May 22, 2019

RE: Grandview Reserve
Part of the S ½, Sec. 21, Part of the S ½ Sec. 22, Part of the N ½ Sec. 27, Part of the N ½ Sec. 28, all in T12S, R64W, 6th P.M.
Water Division 2, Water District 10
Upper Black Squirrel Creek Designated Basin

We have reviewed your May 6, 2019 submittal concerning the above referenced proposal for the subdivision of 768.23 acres into 184 lots.

EXHIBIT B

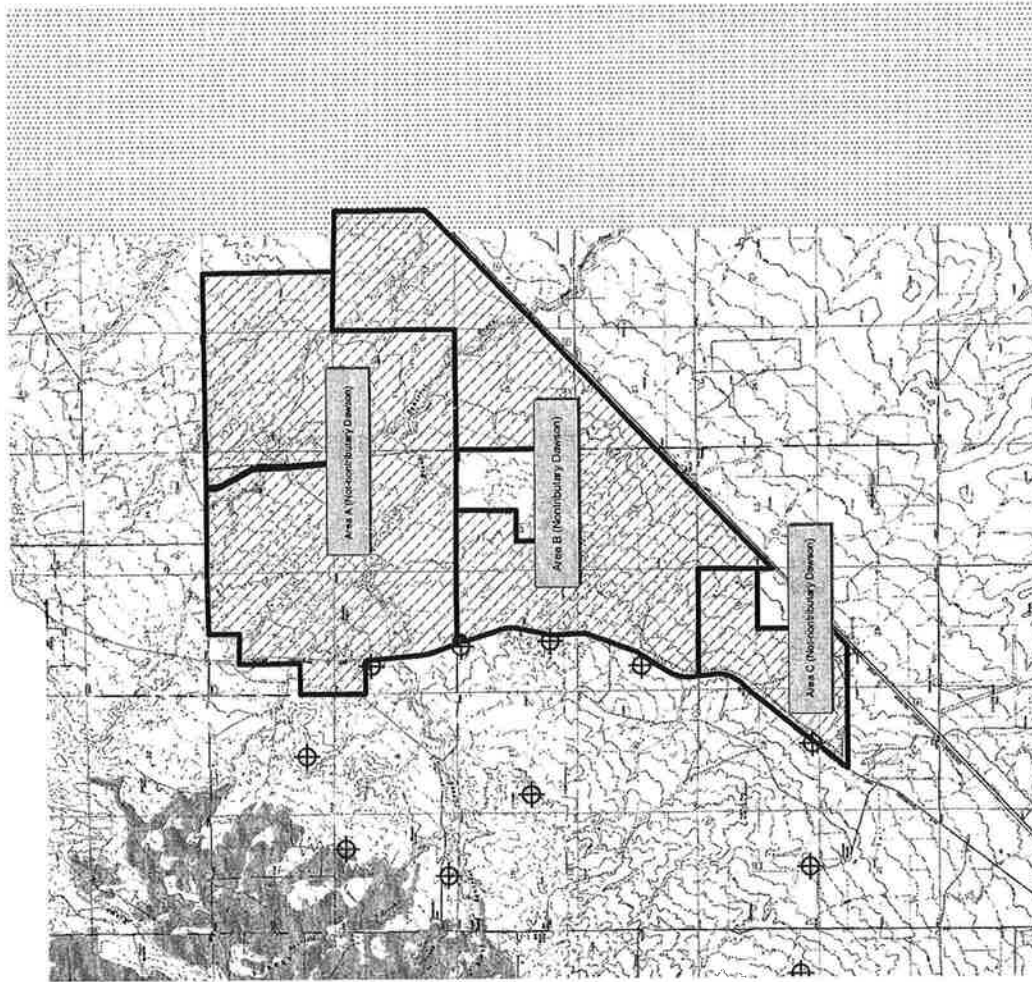
A map within Appendix A of the Water Resources Report shows a number of lots will overly both Areas B and C of 1438-BD. For those lots that overly both Areas B and C of 1438-BD, the Water Resources Report has not identified whether the location of the well on such

lots with be within Area B or Area C of 1438-BD, and so whether the water to be withdrawn by the well on that lot would be nontributary or not-nontributary ground water.

1. A replacement plan must be required for the withdrawal of the not-nontributary ground water underlying Area C of 1438-BD.
2. The applicant must list, by lot number, which lots will have wells that withdraw nontributary ground water underlying what is referred to as Area B in 1438-BD, and what lots will have well that withdraw not-nontributary ground water underlying what is referred to as Area C in 1438-BD. The submittal should not rely on the map within Appendix A of the Water Resources Report to provide those lot numbers. For those lots that overly both Areas B and C of 1438-BD, the applicant must provide clarification, for future lot owners, whether the required location of the well must be within Area B or Area C of 1438-BD.
3. The applicant must identify the number of square-feet of irrigation or number of stock that would be allowed to be served by each well.
